Application for Removal or Variation of a Condition following Grant of Planning Permission or Listed Building Consent

Northdene

Proposed extension to the current ground floor of the dwelling house to provide a utility room and in addition, to alter the current garage to the rear of the dwelling house by extending it to form an indoor swimming pool.

3/2013/0584

south elevation

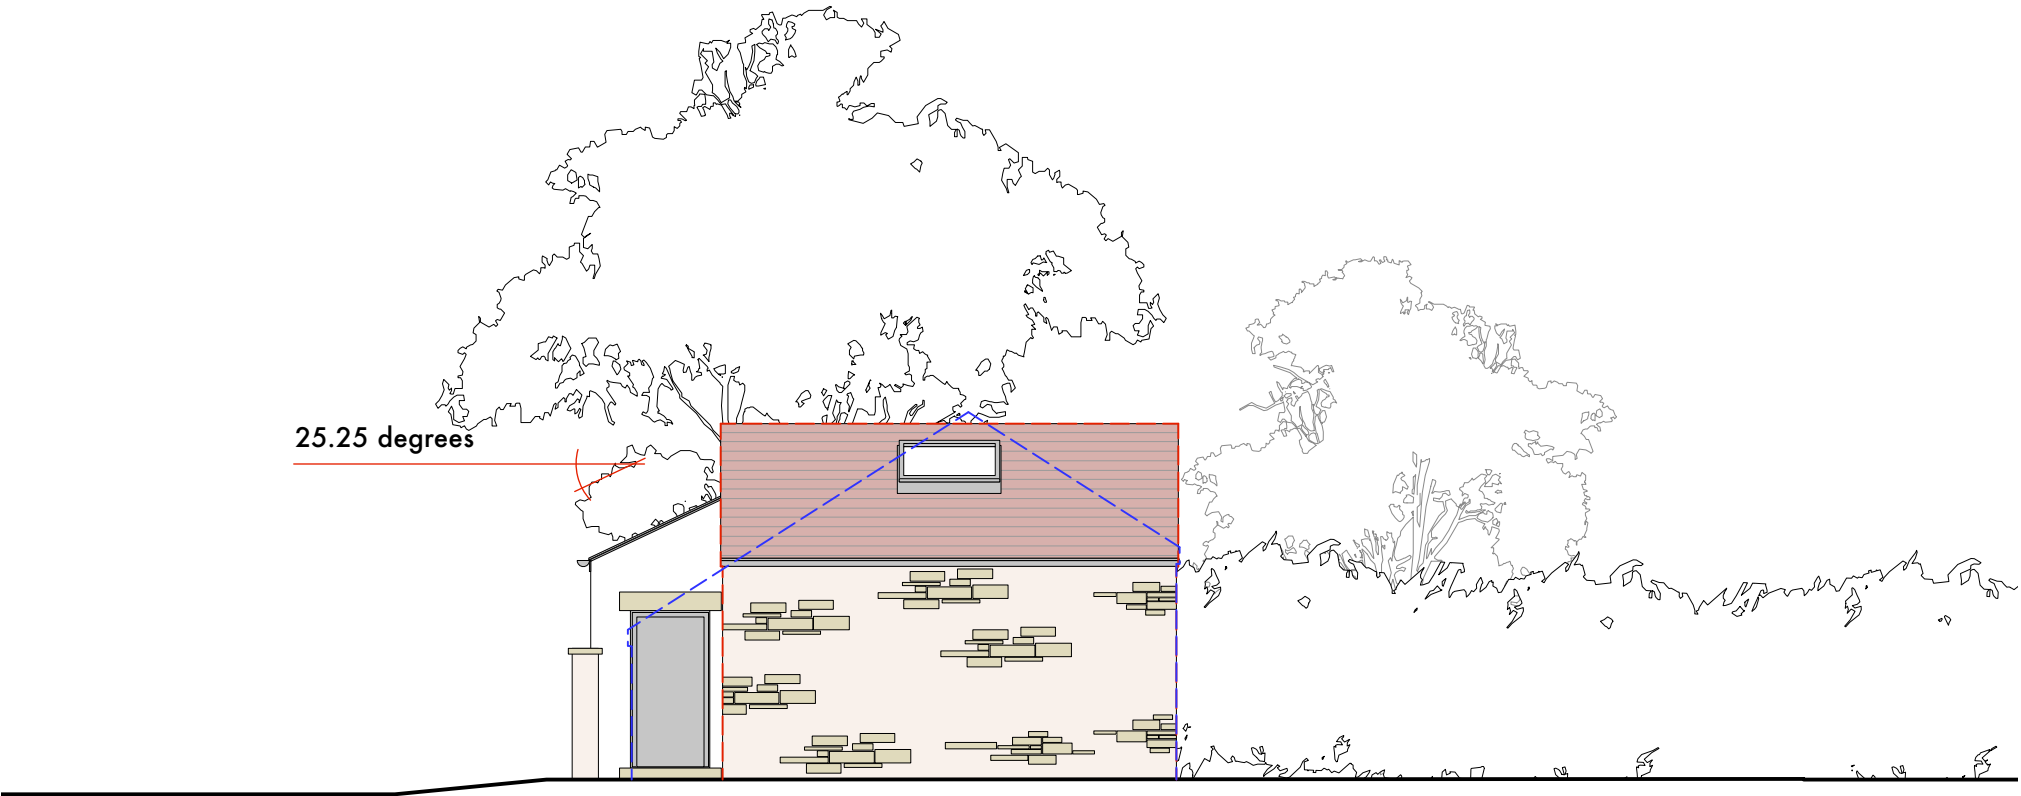
Condition 2 relates to the drawings for the proposed swimming pool DRG NO: P308_002P1 Rev2. This drawings shows the existing garage demolished and replaced by a new building. Our client (the applicant) would like to retain the garage and build a smaller extension. This condition should be changed.

Condition 2 should be changed to the following:

The permission shall relate to the development as shown on plan reference:

Proposed Garage/Garden Room Plans and Elevations - DRG NO: 2275/PL01revA.

drawing number
D.01

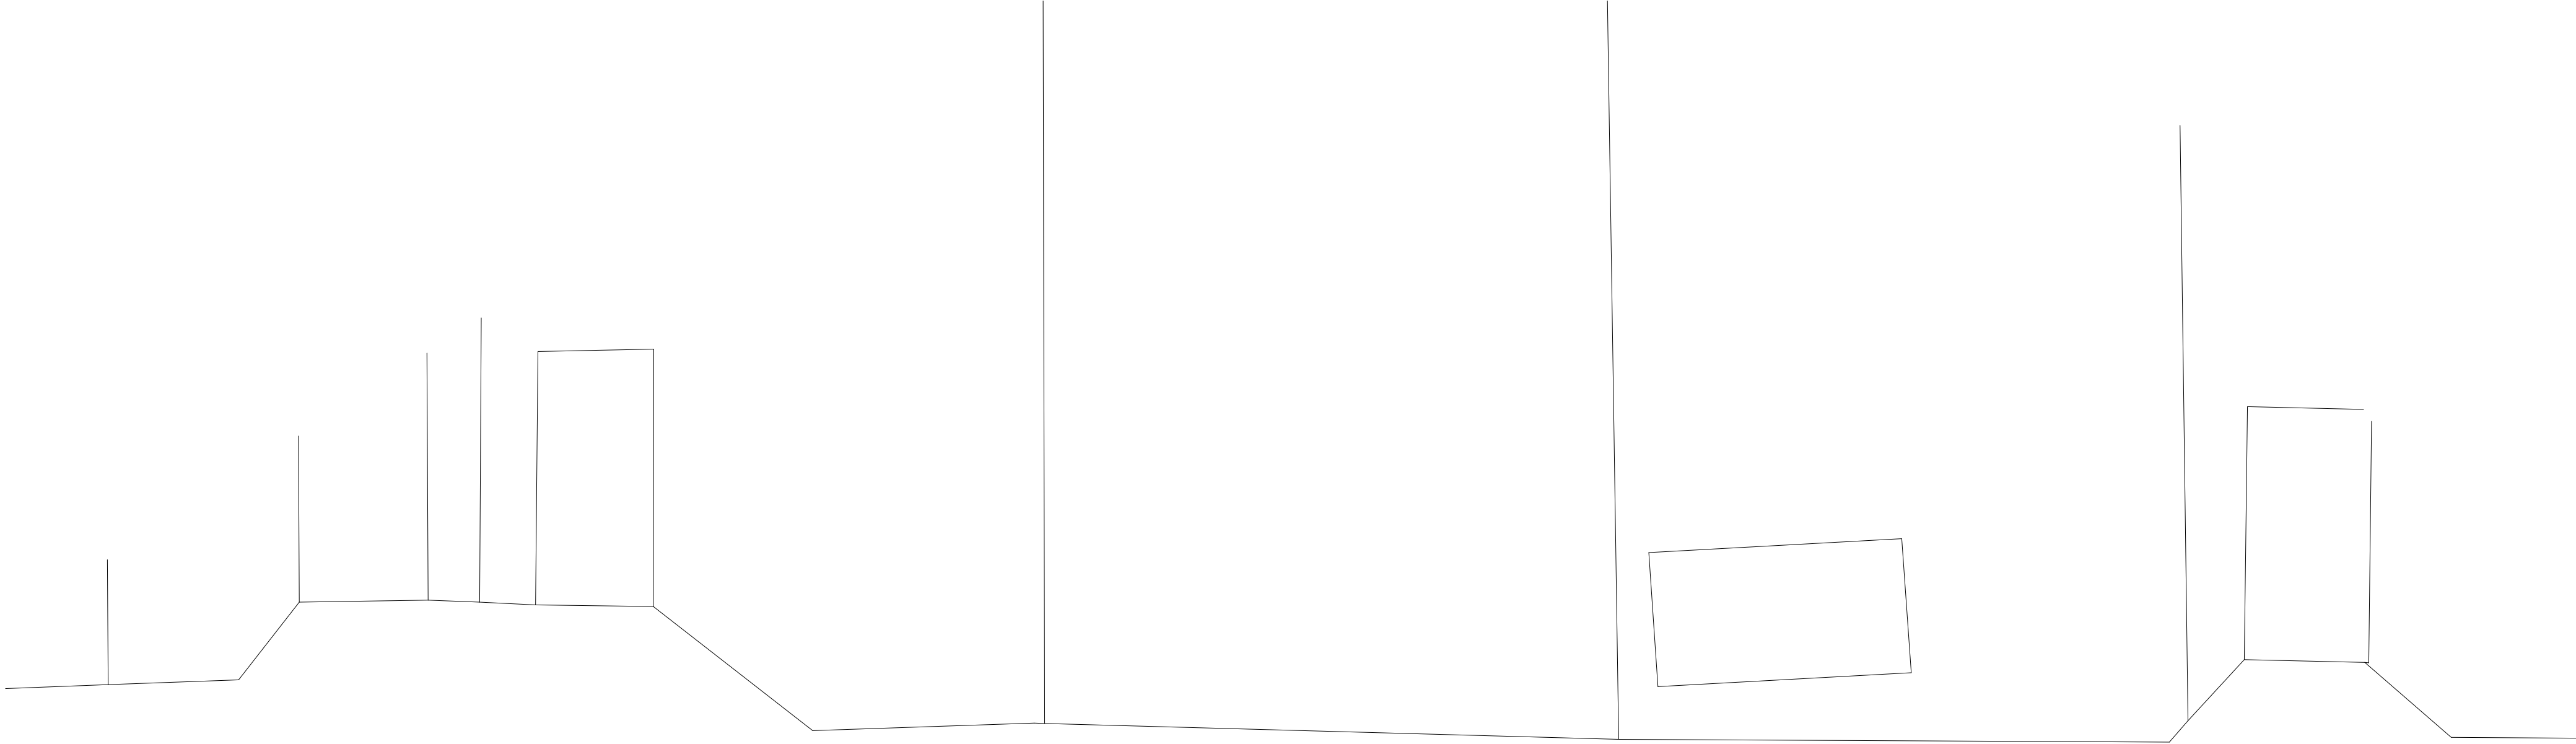
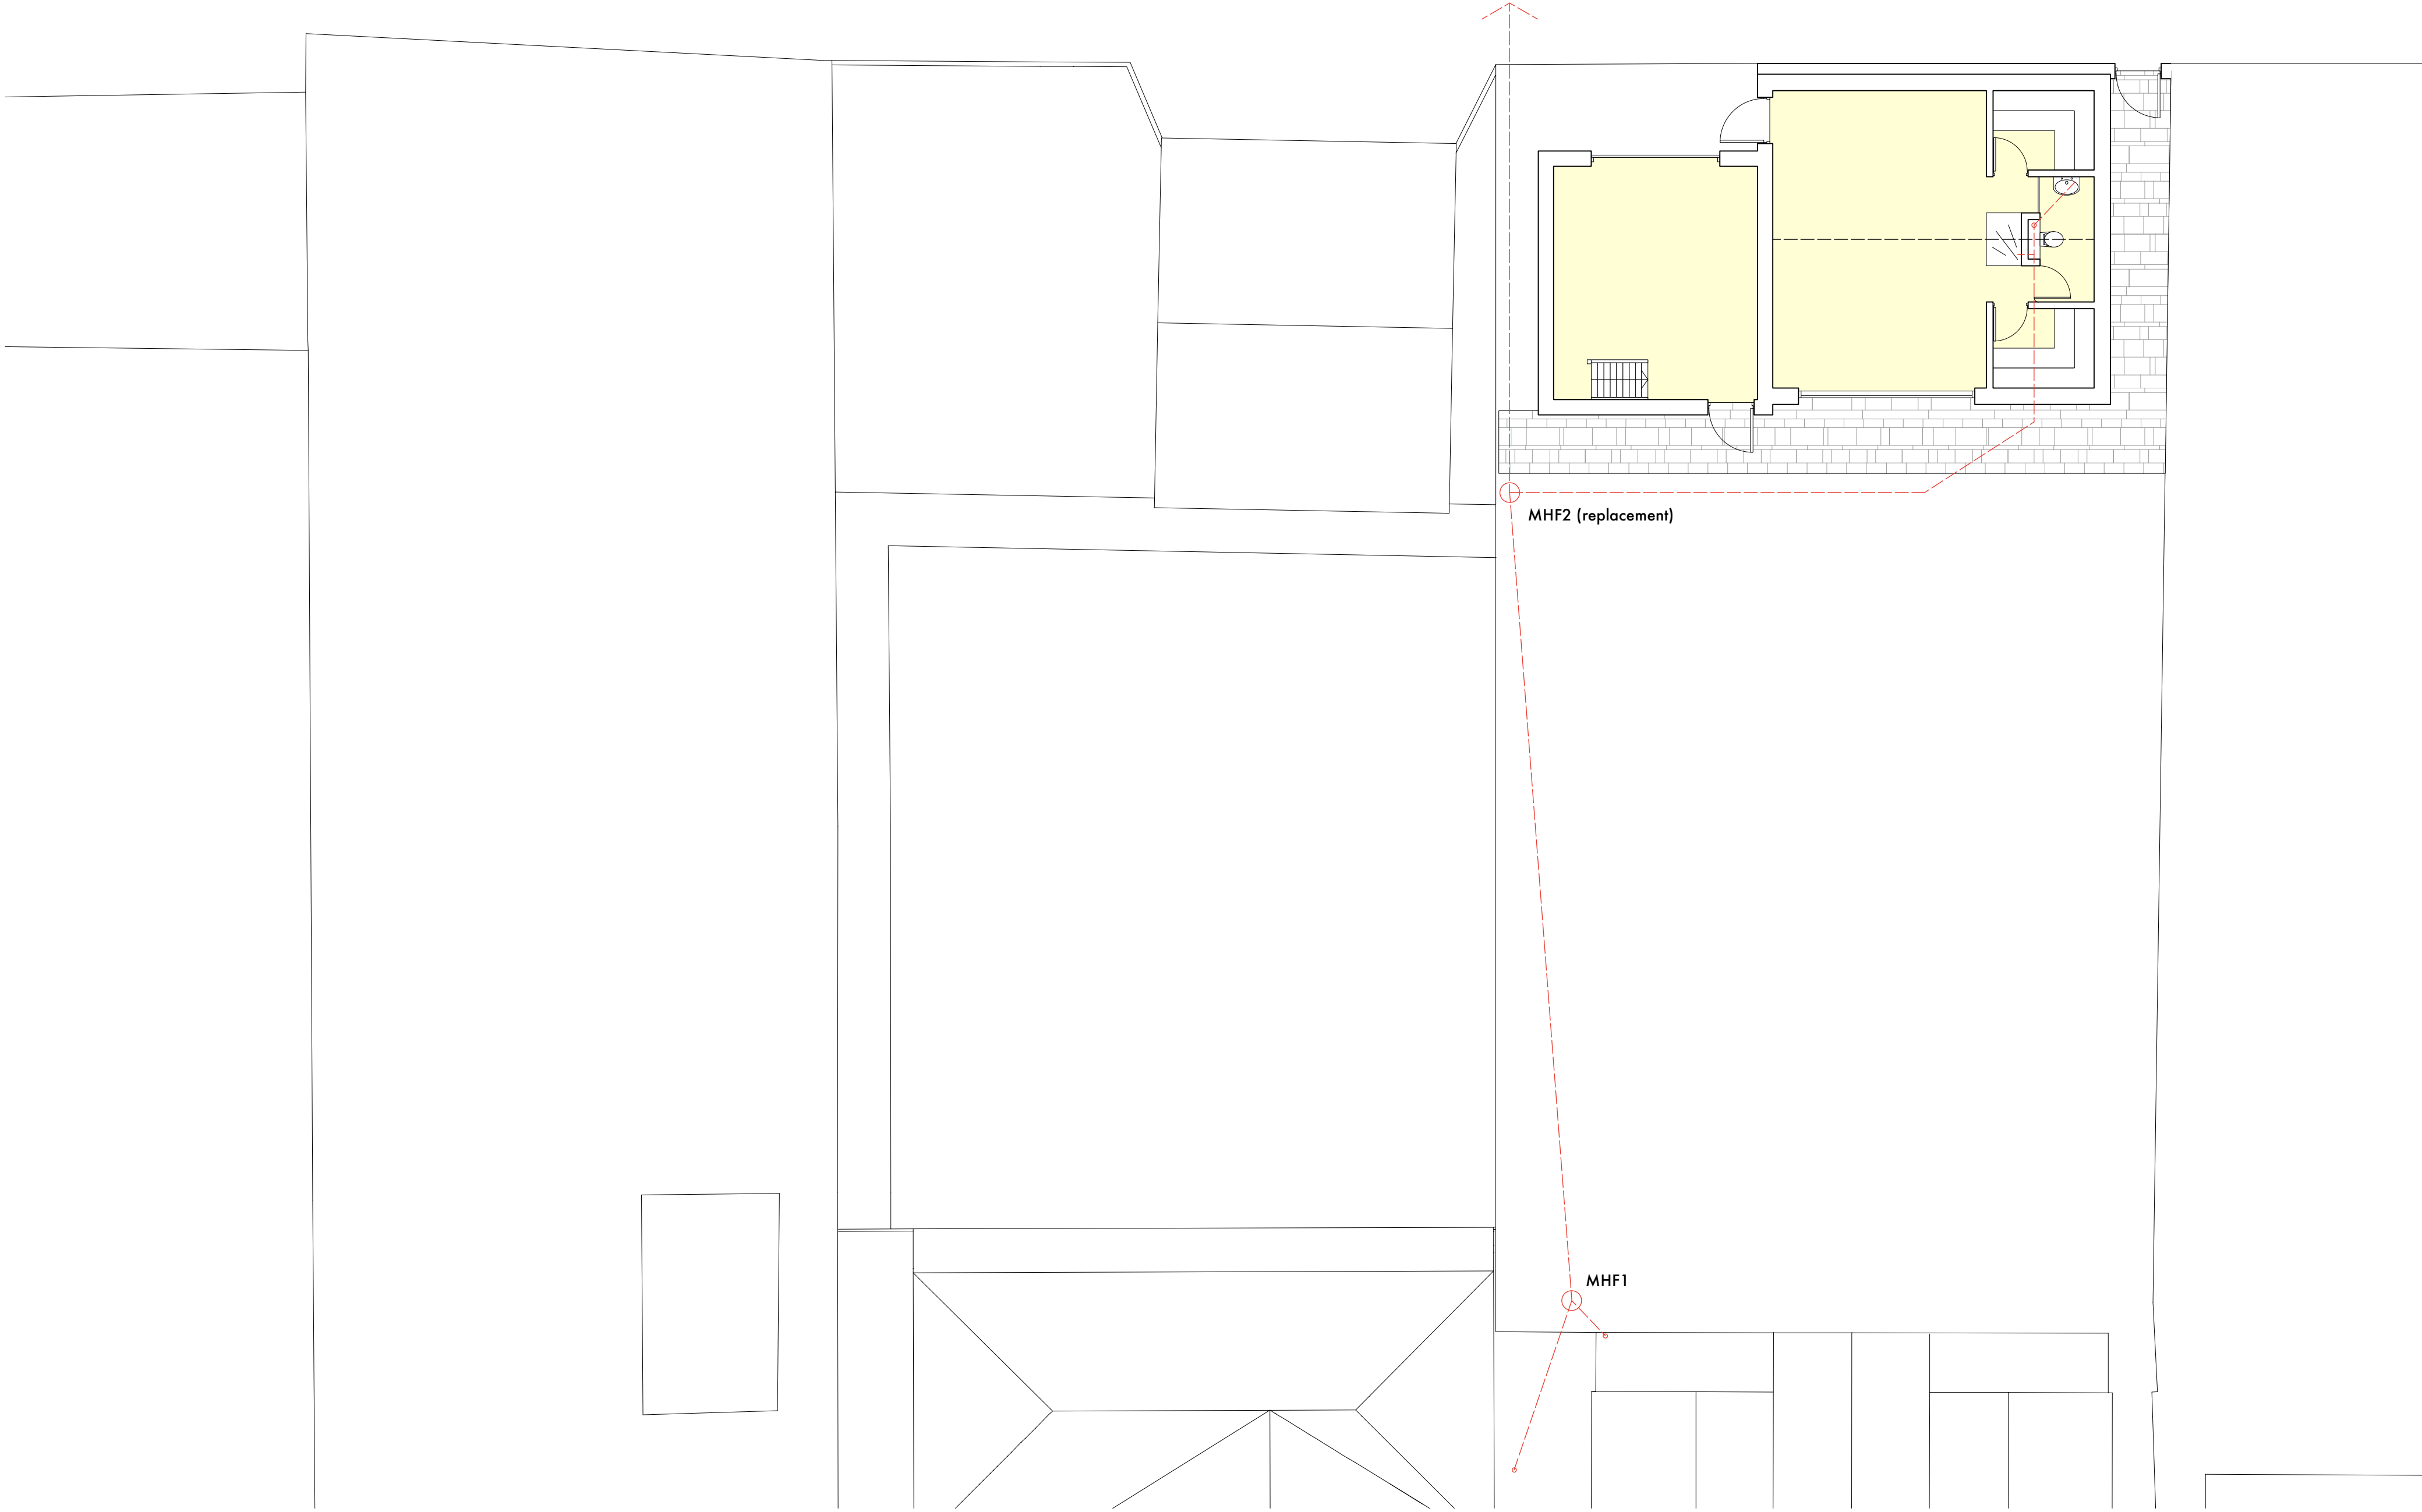
Condition 6 should be removed regarding drainage as this information is provided on drg.no.2275/D01 submitted as part of this variation application.
